LAND AT SALT BOX, BOGNOR REGIS

INDEPENDENT REVIEW OF SURFACE WATER SYSTEM

Date: 28 October 2021

Doc ref: SAL-HYD-R-C-GLOS-0001

CLIENT		
LANDLINK ESTATES		
PROJECT		
SALTBOX BOGNOR REGIS		
TITLE		
HEADWALL DETAILS		
HYDROCK PROJECT NO. C-13319-C		SCALE @ A1 1:25
STATUS DESCRIPTION AS BUILT ISSUE		STATUS A
DRAWING NO. (PROJECT CODE-ORIGINATOR-ZONE-LEVEL-TYPE-ROLE-NUMBER) SAL-HYD-00-ZZ-DR-C-7110		REVISION C04

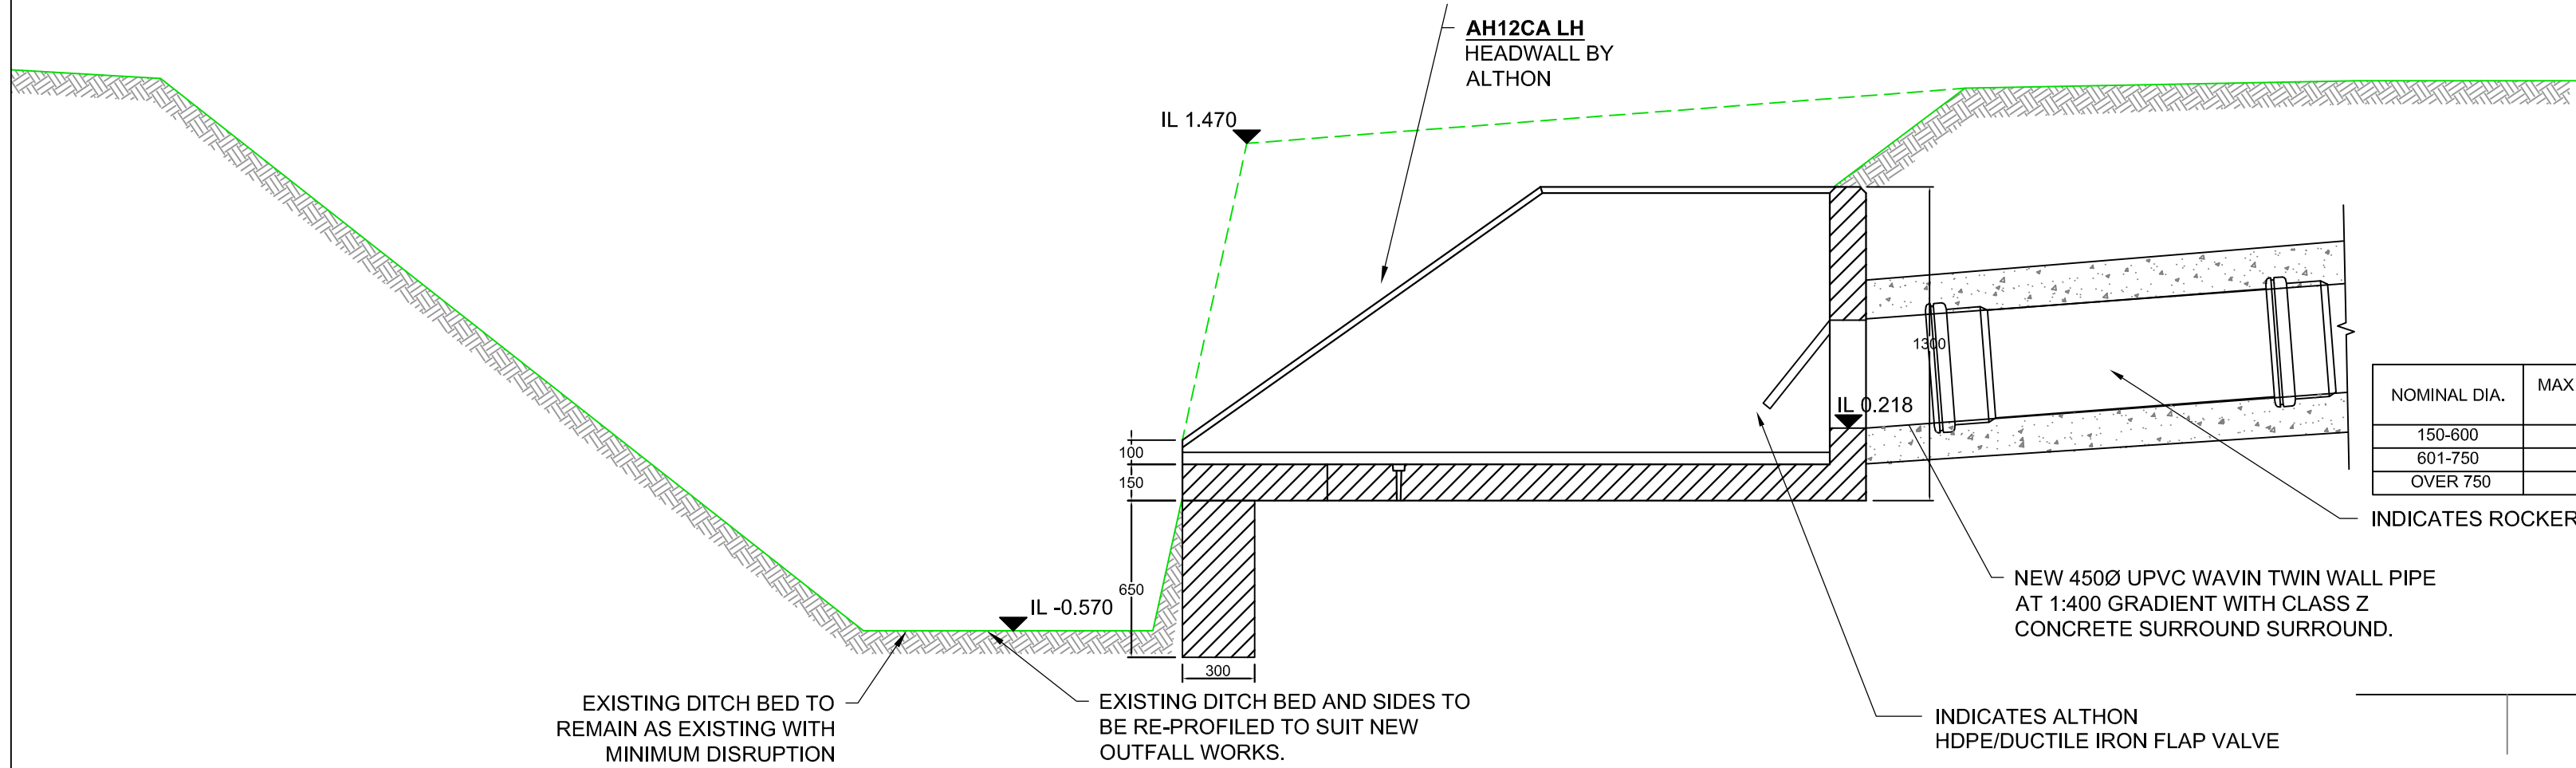
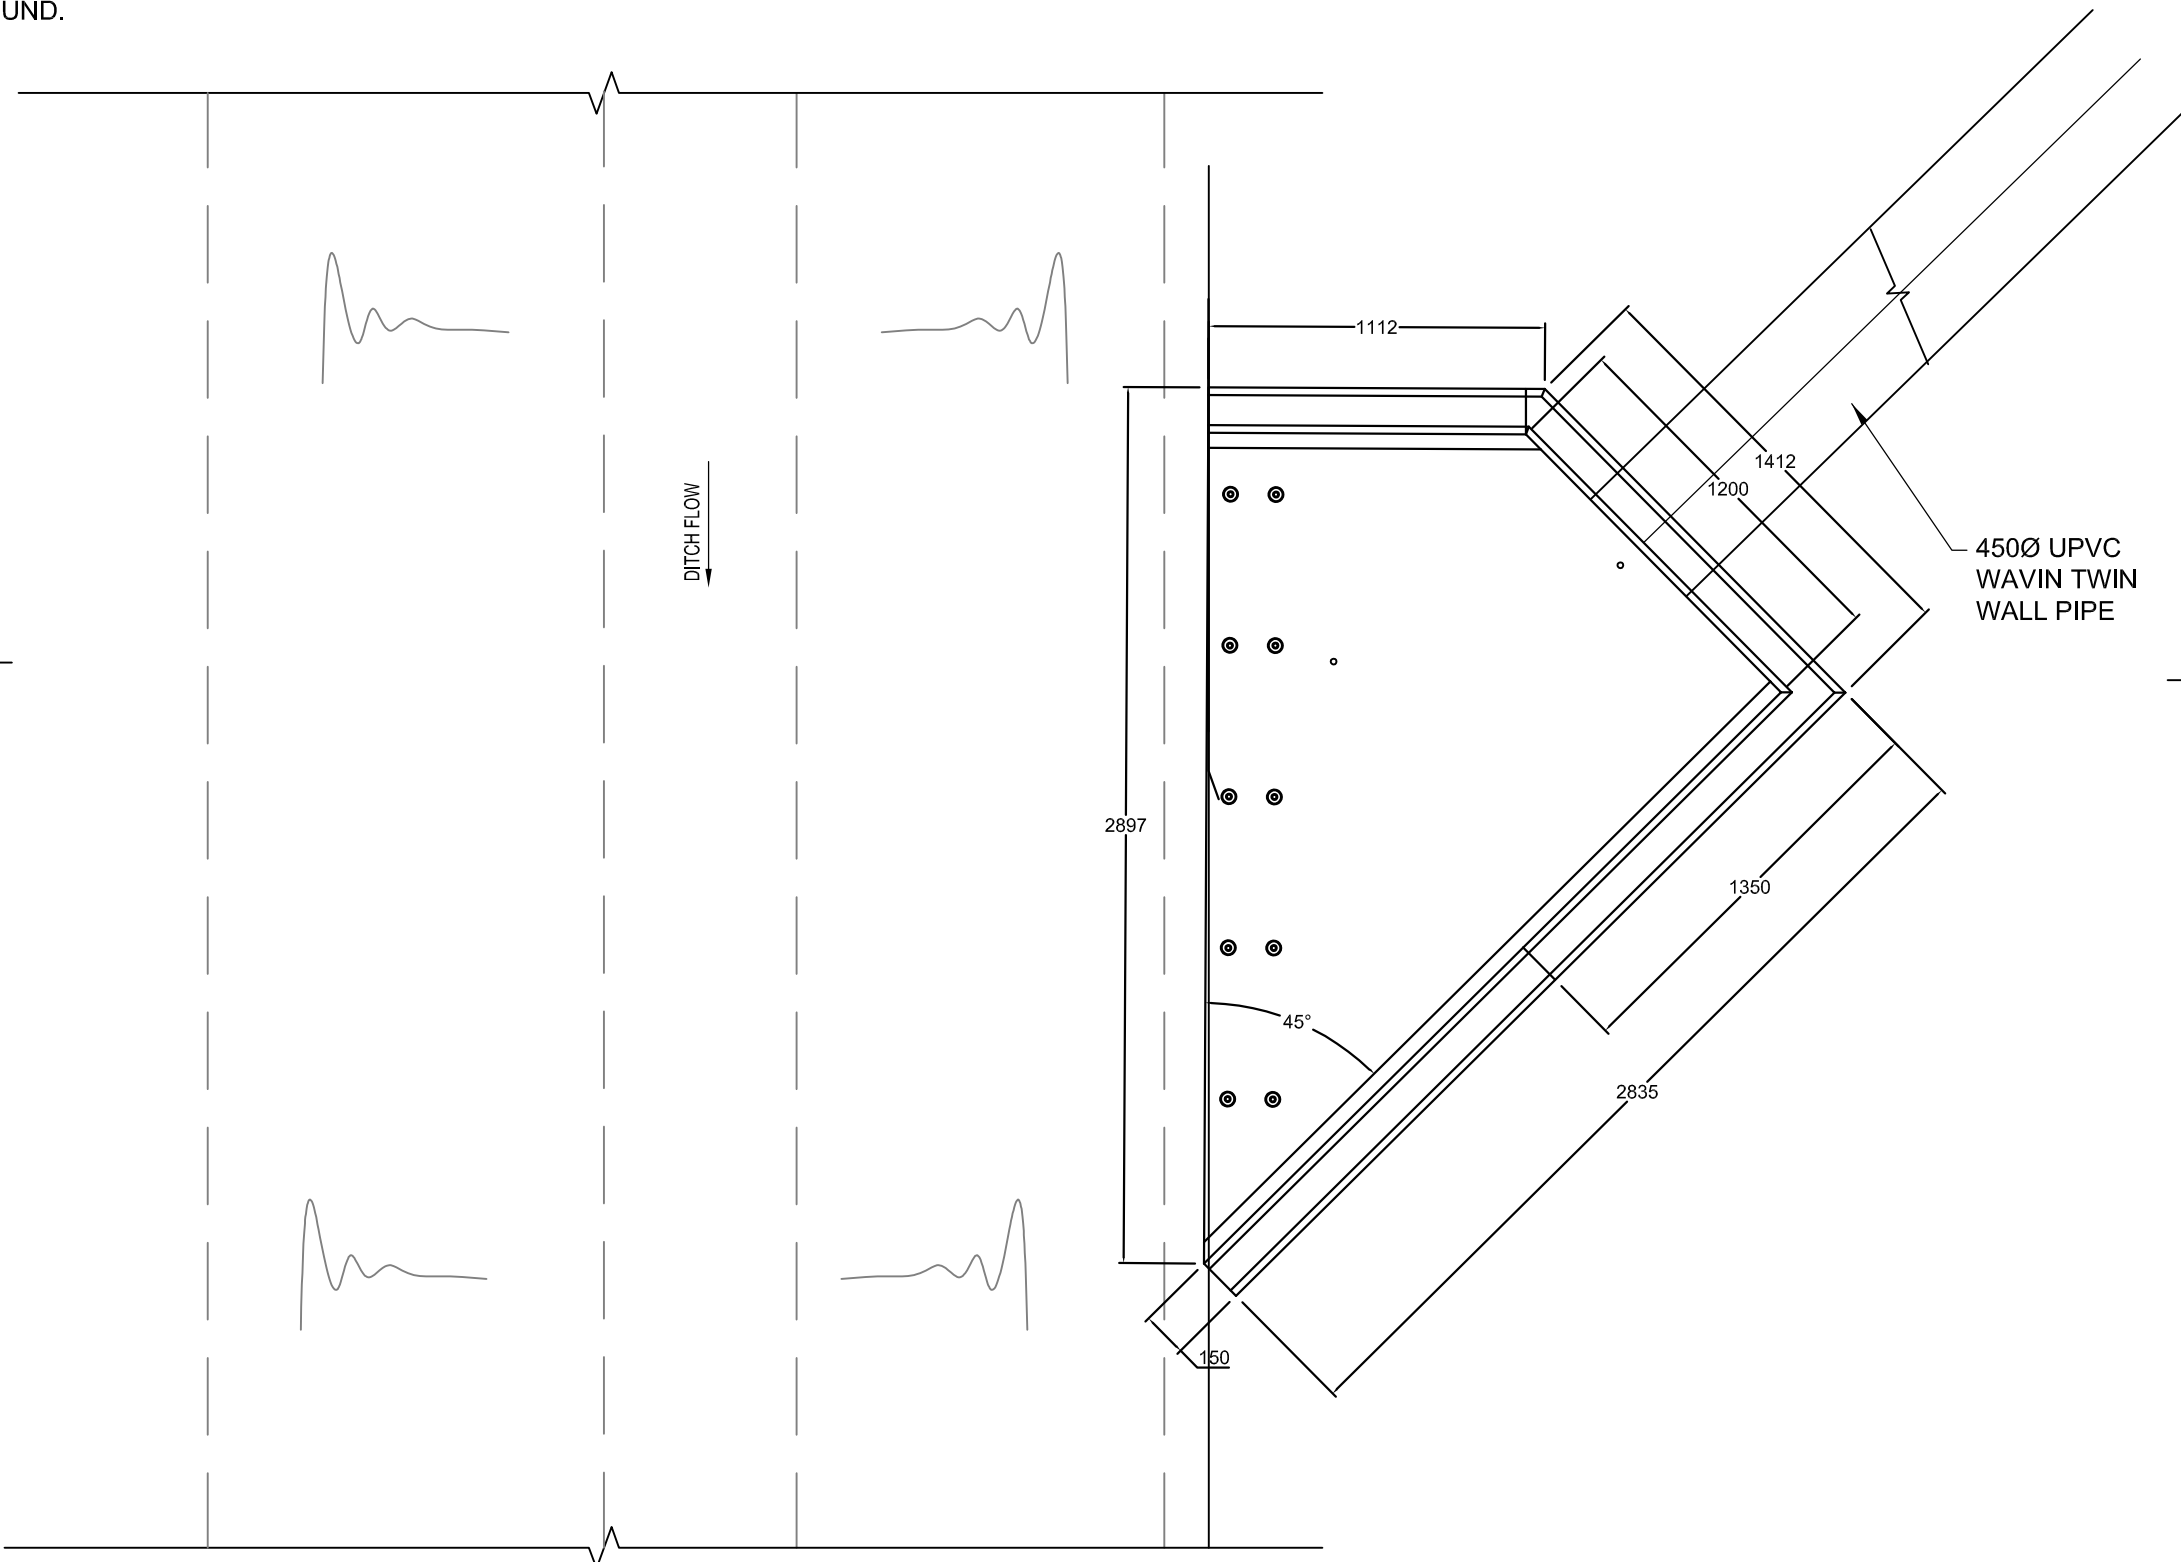
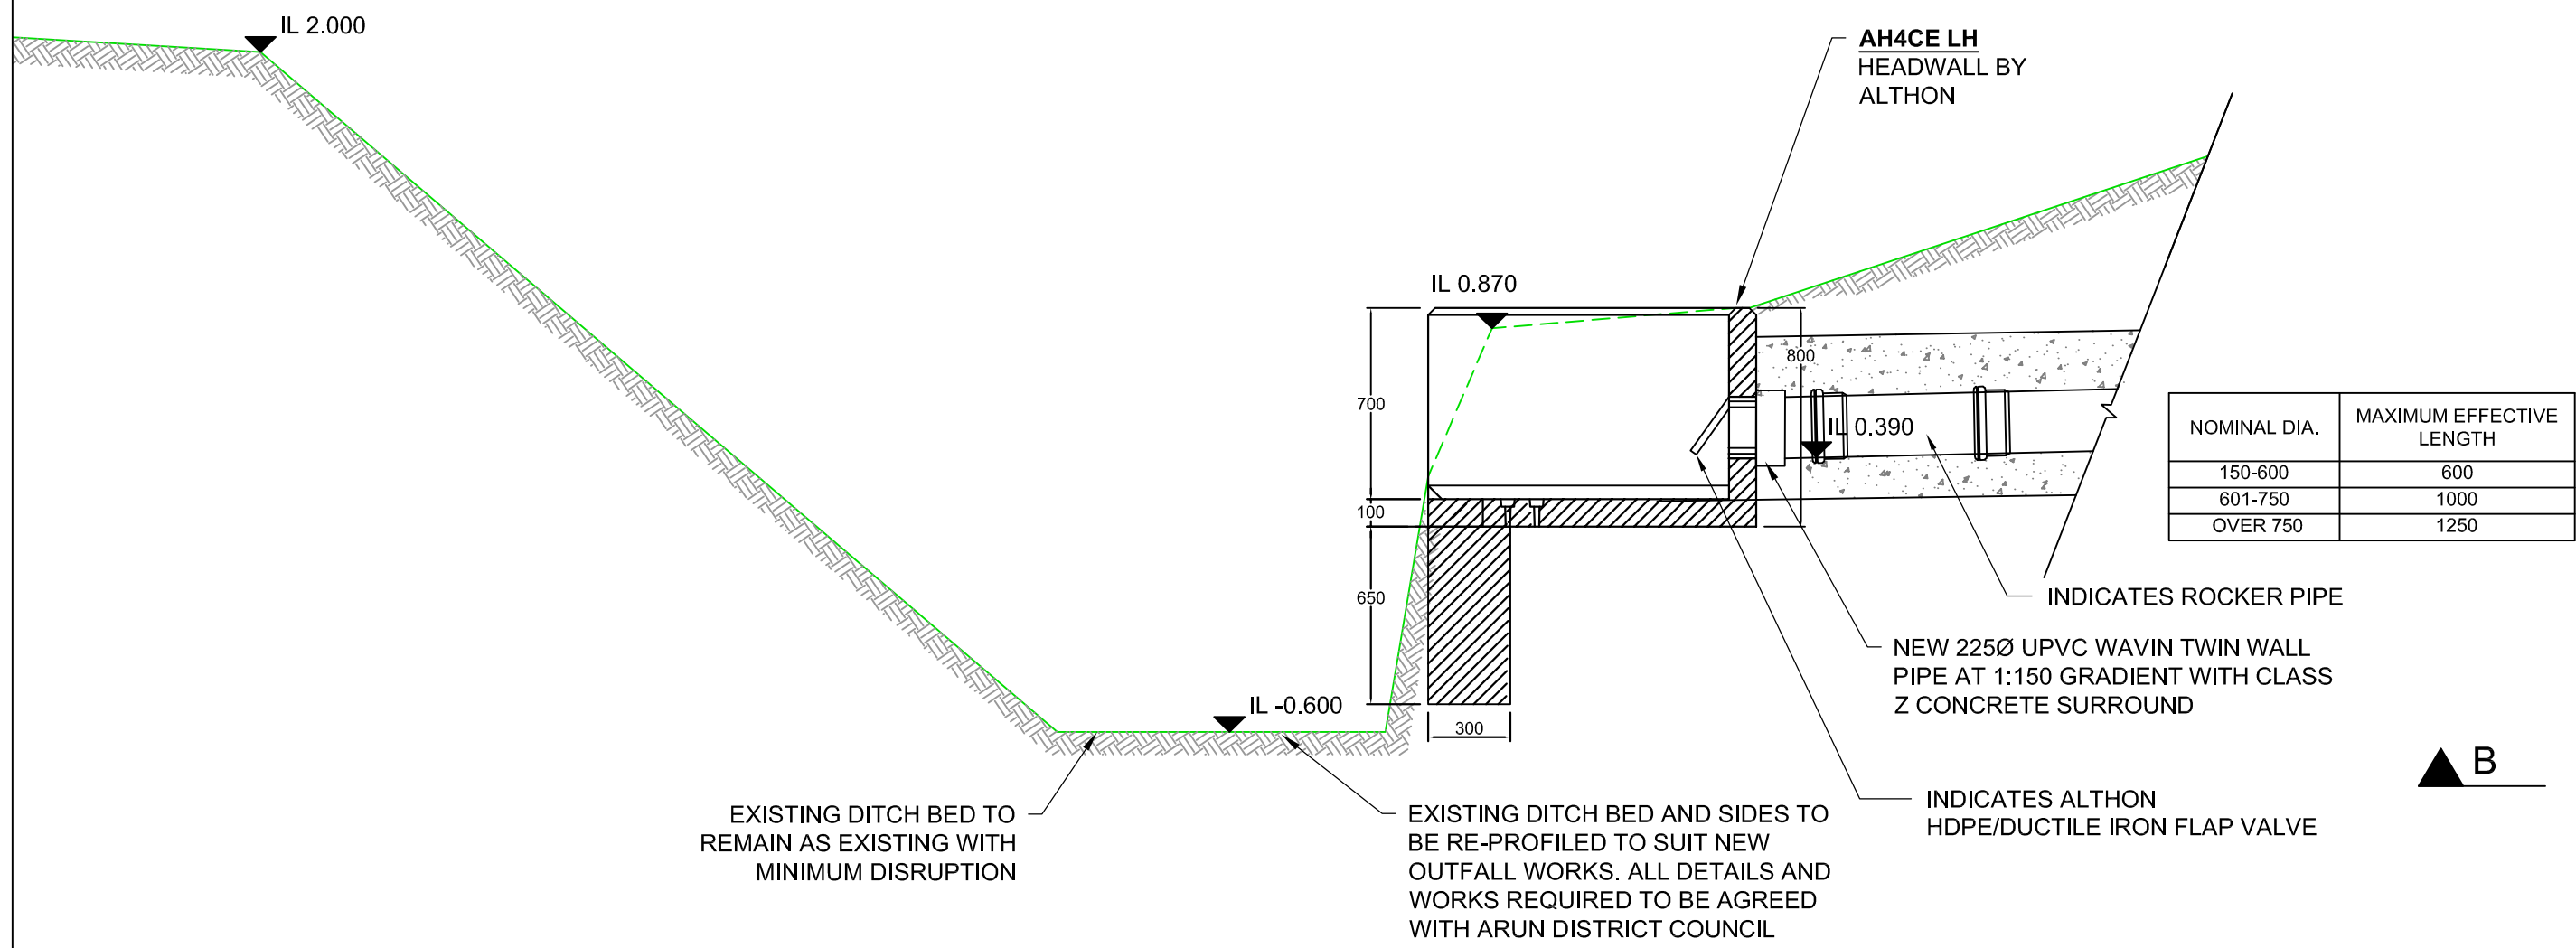
The Environmental Agency (EA) submitted approval permits for the 2 no. headwalls on the 9th February 2021. This permit includes the changes made to the headwall design on Hydrock's layouts and details on the 17th December 2020 from a 90 to 45-degree splayed headwall. This change was requested by Annabelle Kendall of the EA on the 20th November 2020. The reason for the change was to avoid erosion of the opposite embankment, thus negating the need for erosion matting.

This arrangement also allows for easier construction and prevents the need for slow bends into the headwall where it would instead have been repositioned at an angle, thus providing a better system with less maintenance. The headwall used is of same material as designed, provided by Althon, a reputable national supplier of headwalls. I see no issues with the change in design as it is a more beneficial arrangement.
